REQUEST

Current Zoning: ML-1 (manufacturing and logistics-1)
Proposed Zoning: ML-1(CD) (manufacturing and logistics-1, conditional)

Approximately 17.31 acres located along the east side of Twin Lakes Parkway and north side of Interstate 485, south of Sam Roper Drive.

PLANNING STAFF REVIEW

Rezoning Plan
 Charlotte NC 28212

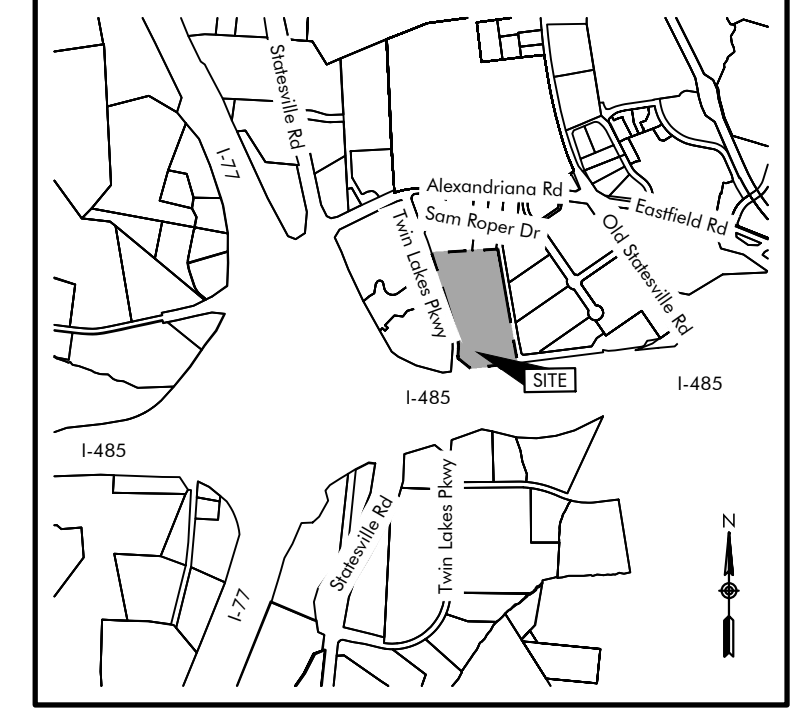
1. Land use information has been added to the site plan but no density information. Please add maximum density information to the site plan to confirm data provided in trip generation memorandum.
